Our Ref: FP/30/20/PL
Your Ref:

Town & Country Planning Act 1990 (as amended)
Town & Country Planning (Development Management Procedure) (England) Order 2015
Application for Planning Permission for Works or Extension to a Dwelling

Development Rear staircase
Location 9A Felpham Road Felpham

Proposed South Elevation

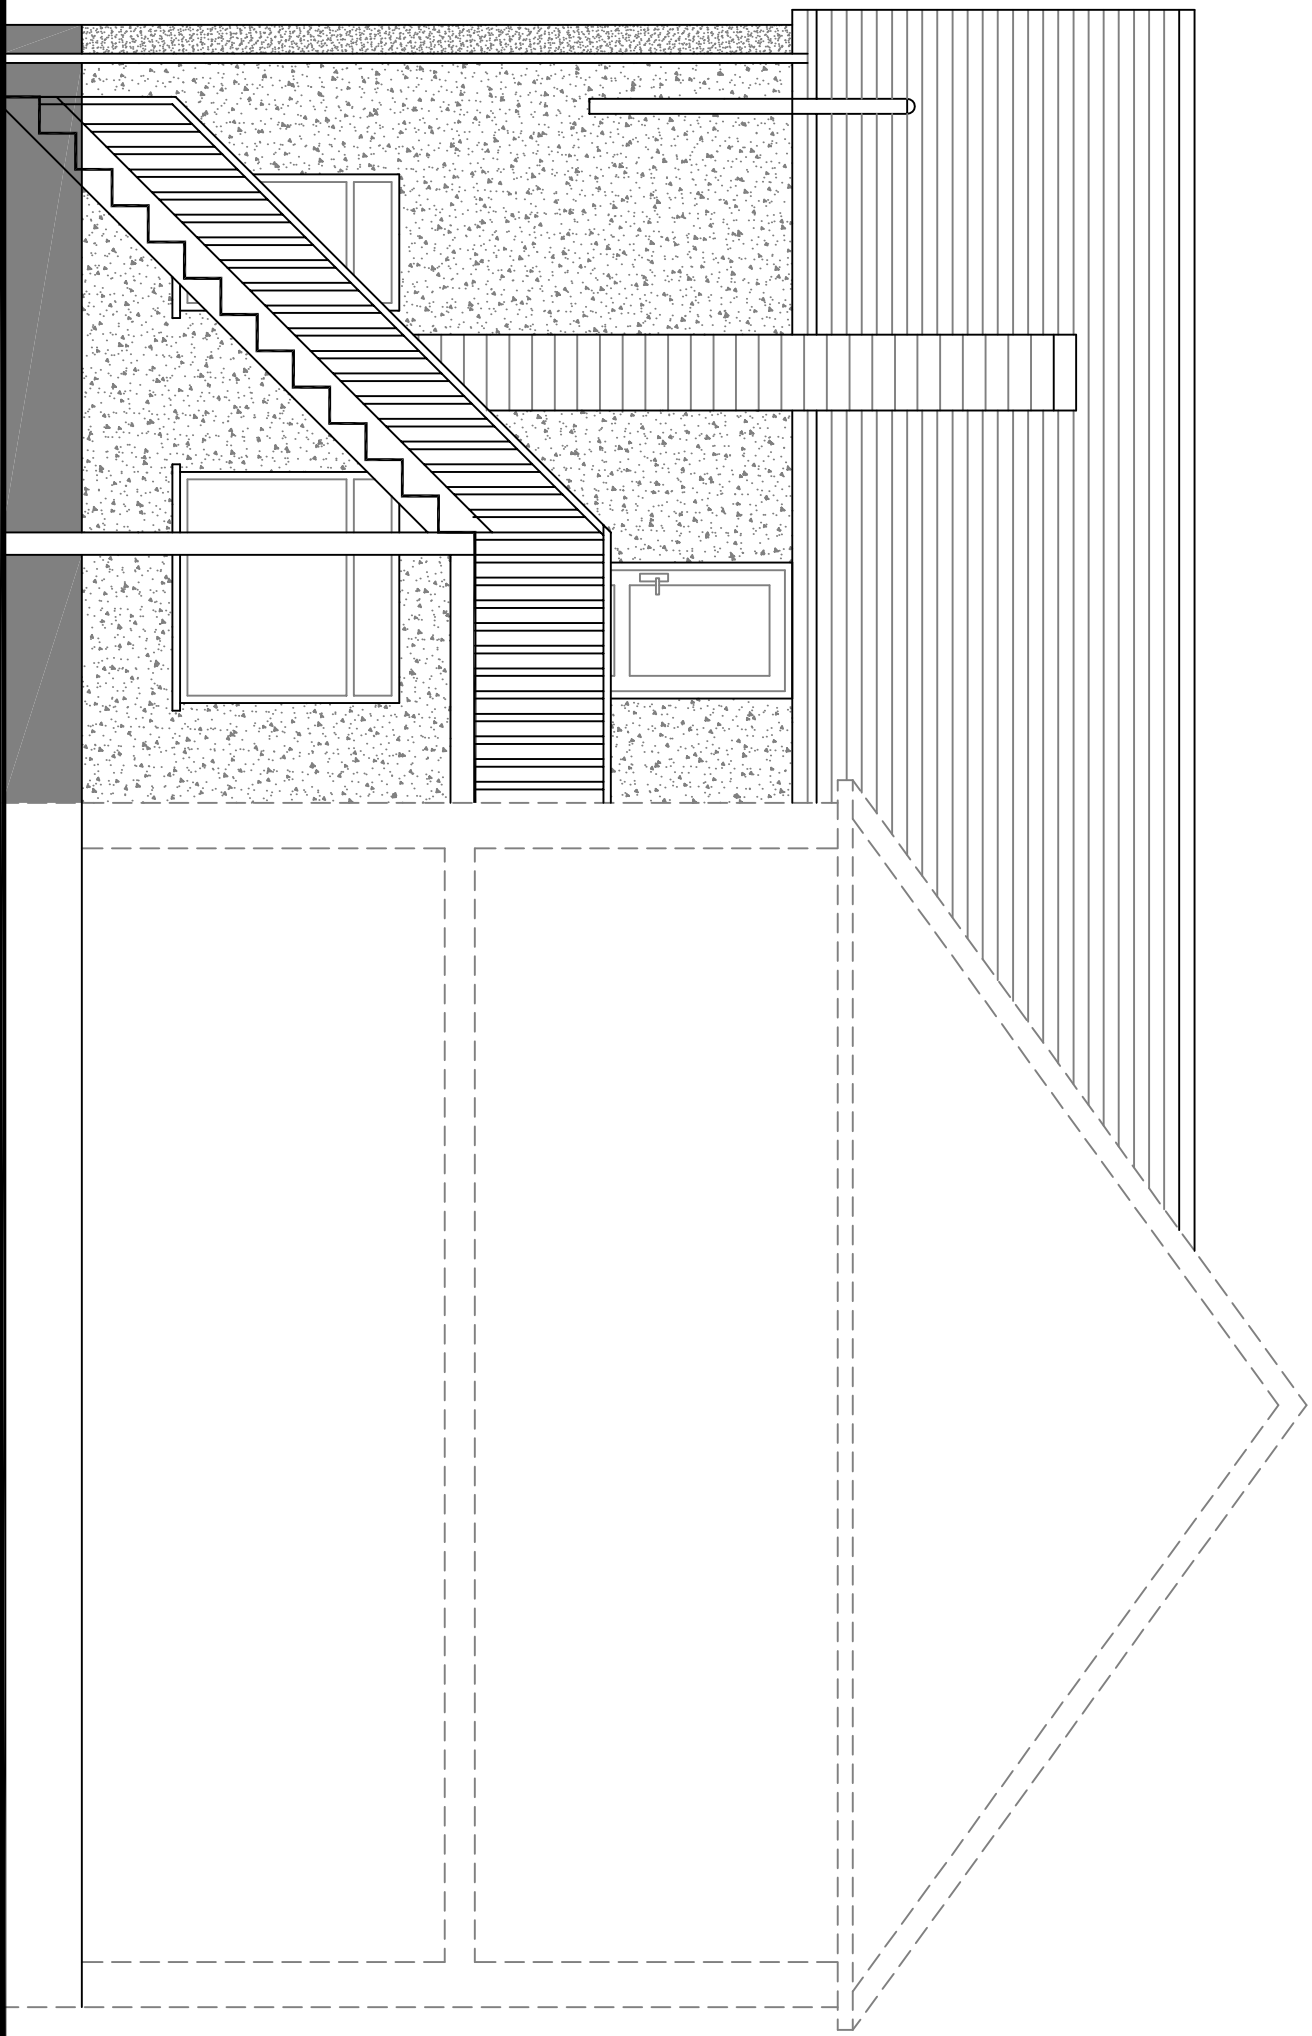
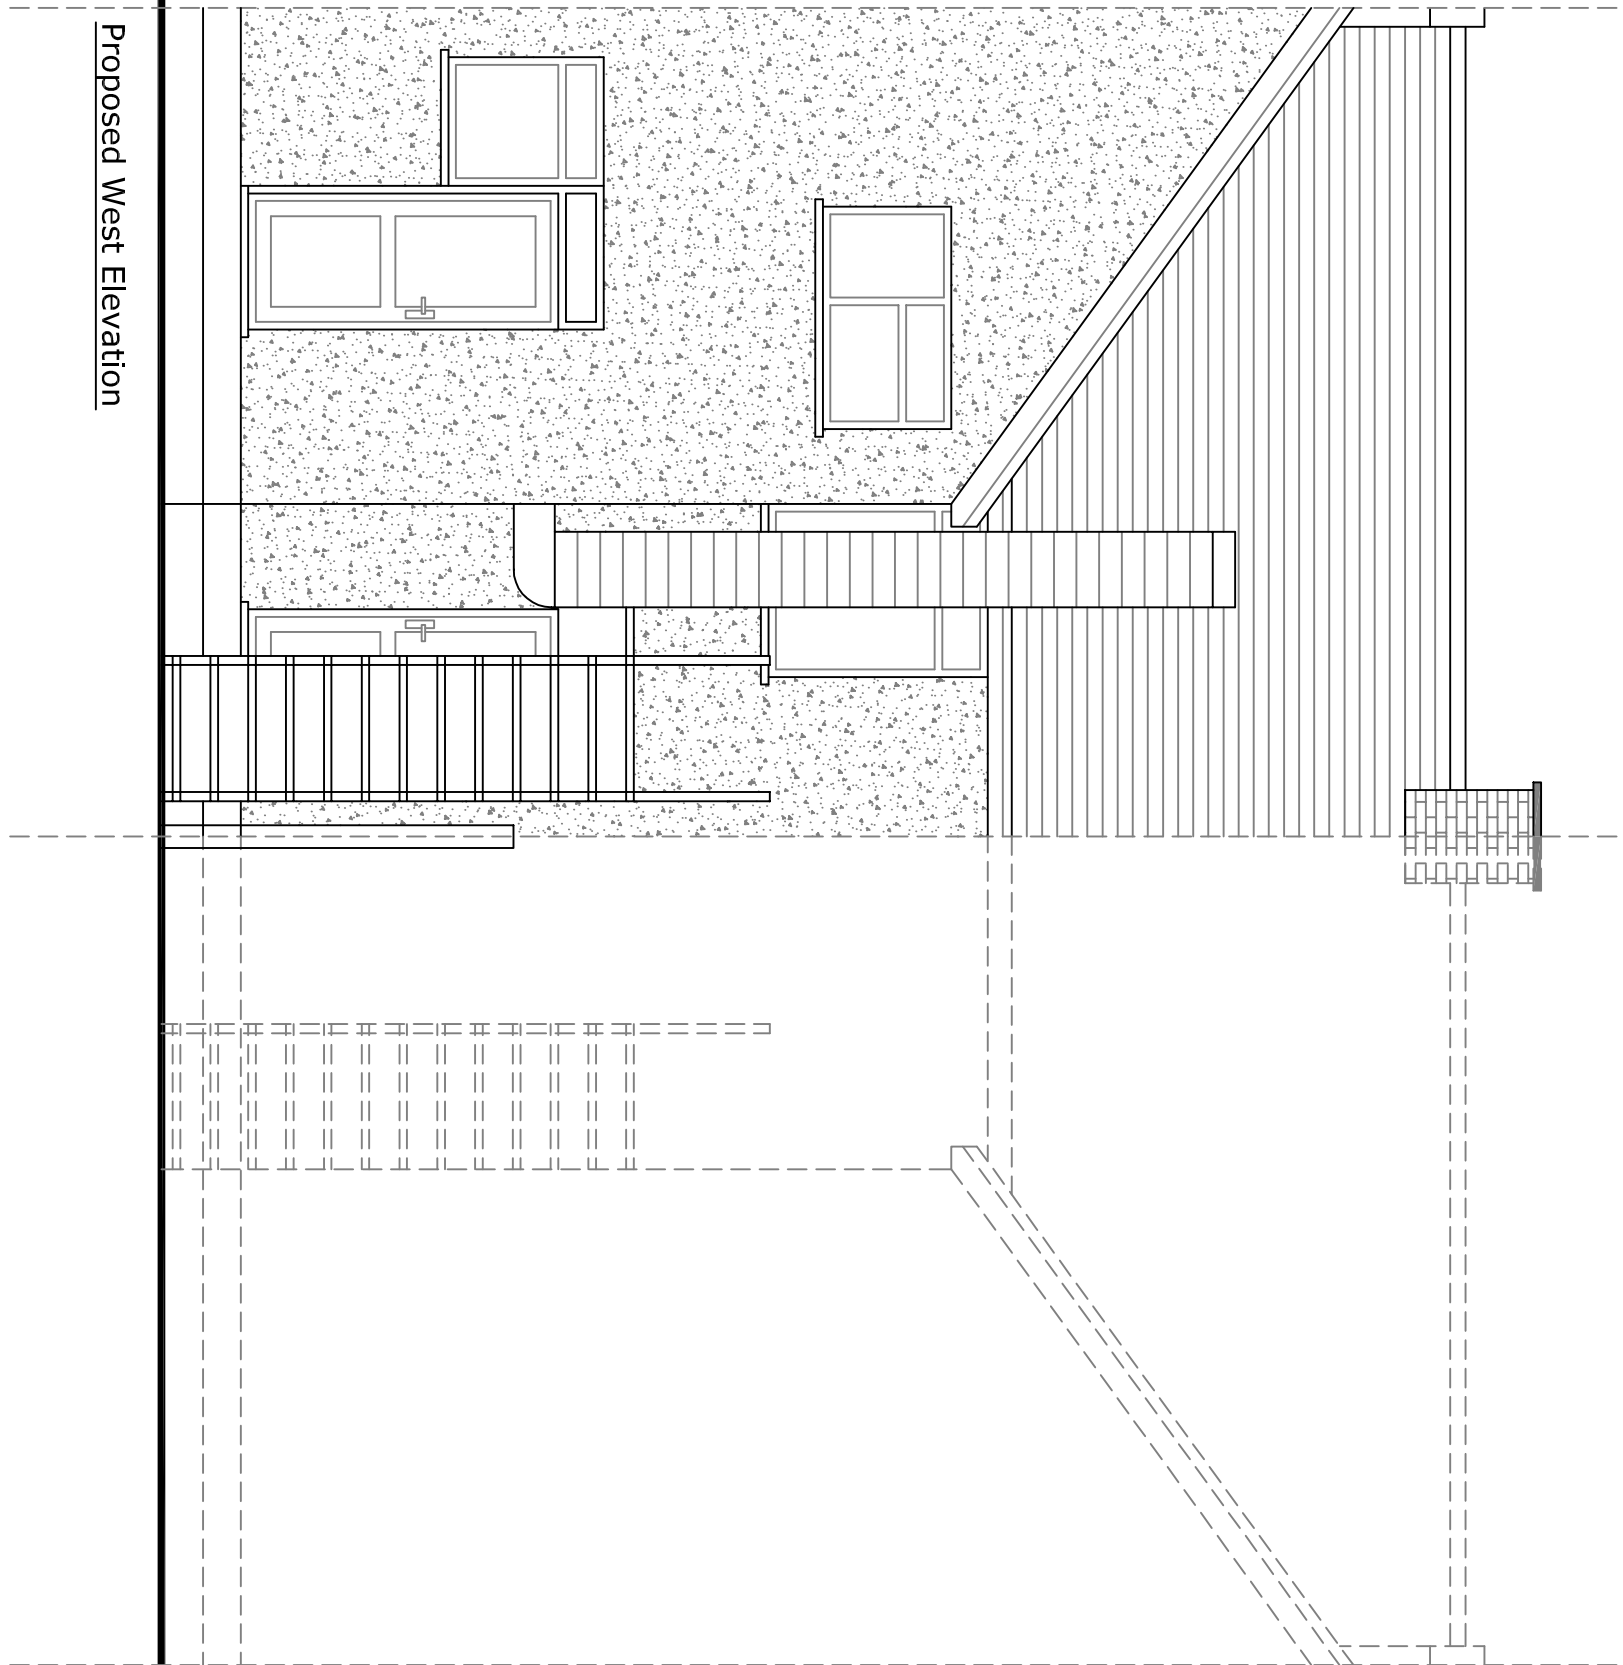
Two elevations have been labelled existing and proposed South elevations. Please amend accordingly.

Please provide existing and proposed west and north elevations.
